From: Charlotte Burrows
Sent: 29 August 2014 08:36
To: [REDACTED]
Subject: RE: Decking changes

LU/233/14/NMA

PROPOSED FLOOR PLAN 1:50

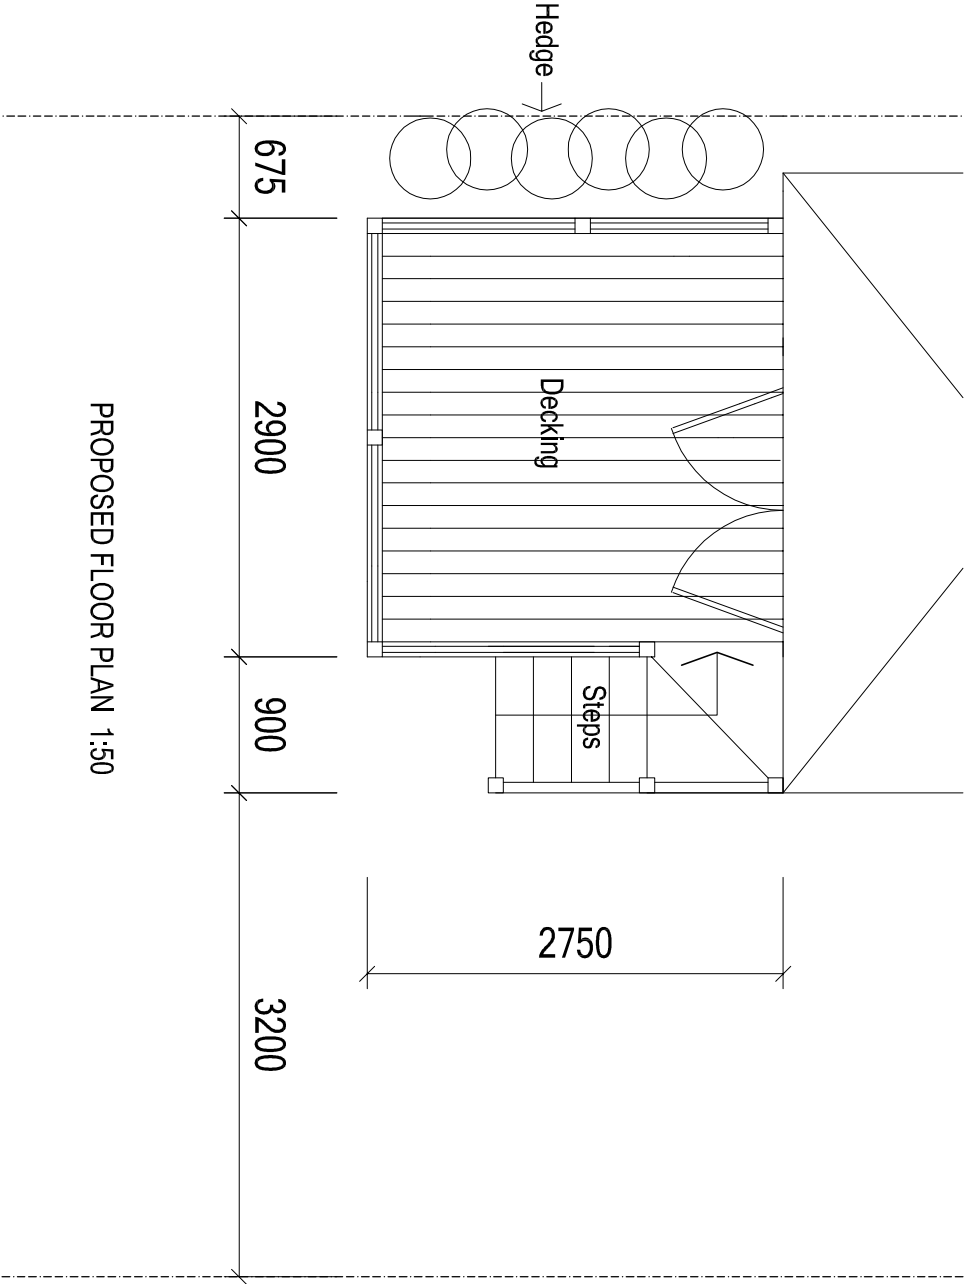
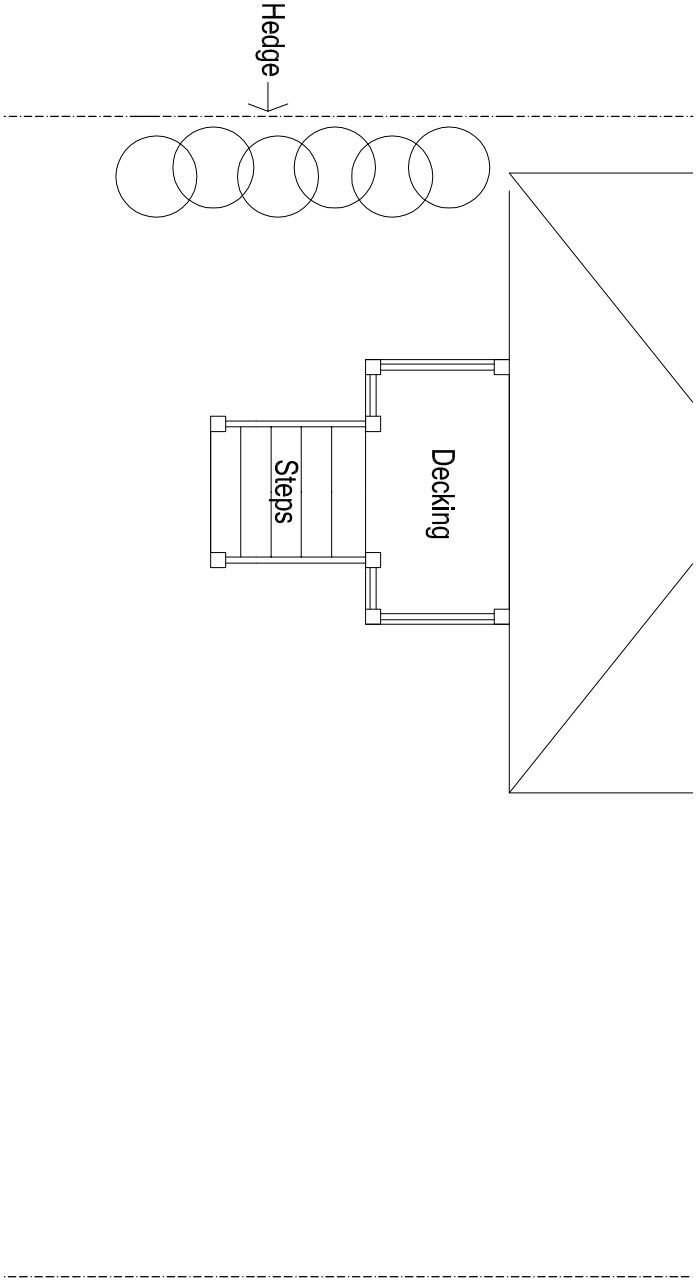
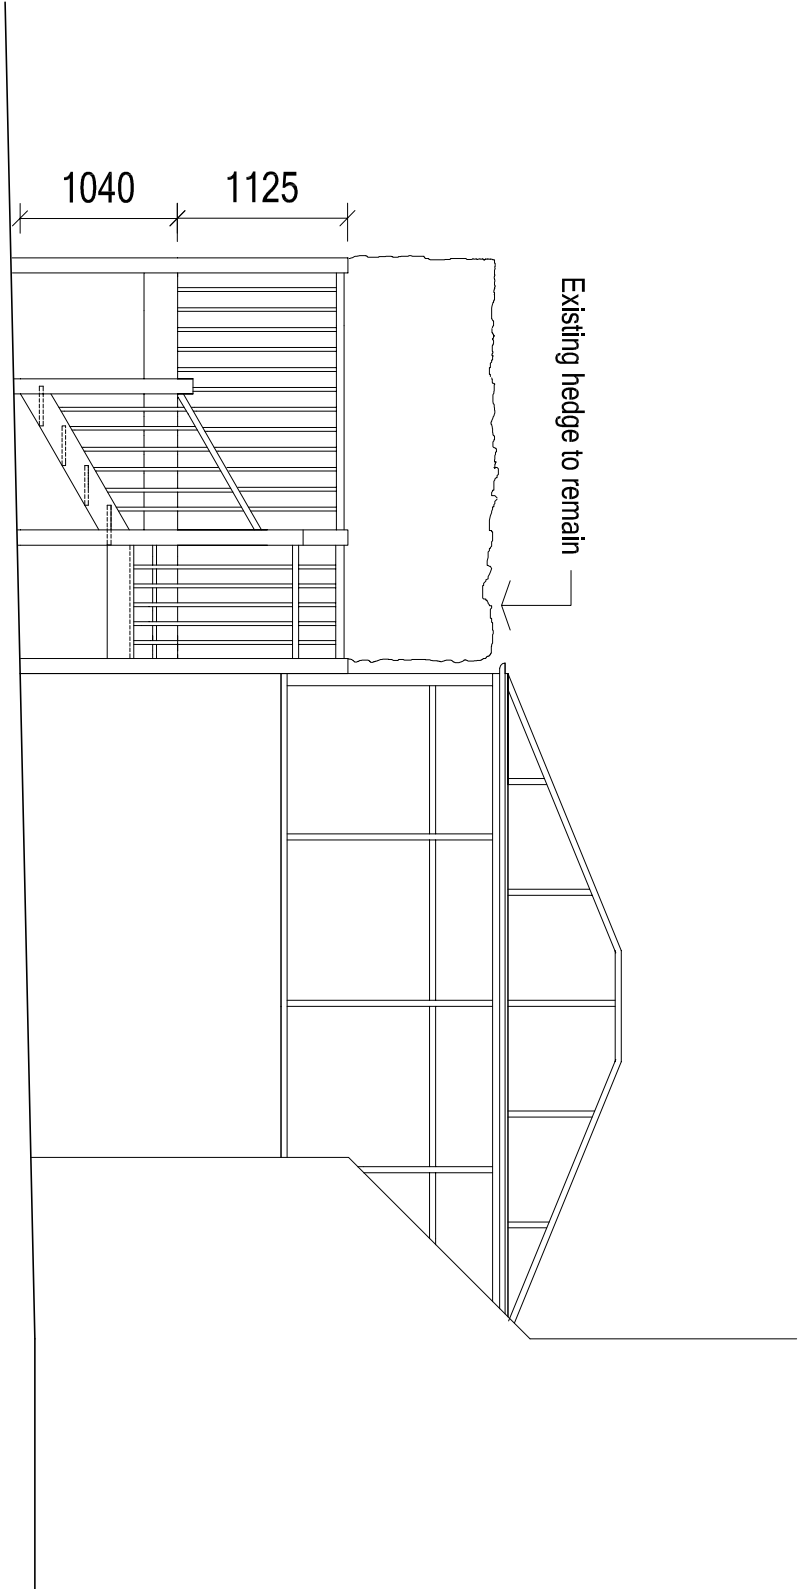
Unfortunately the drawings submitted are still omitting to show the hedge, I have discussed this with the Team Leader for the area and we will require the hedge to be clearly indicated on the proposed plans.
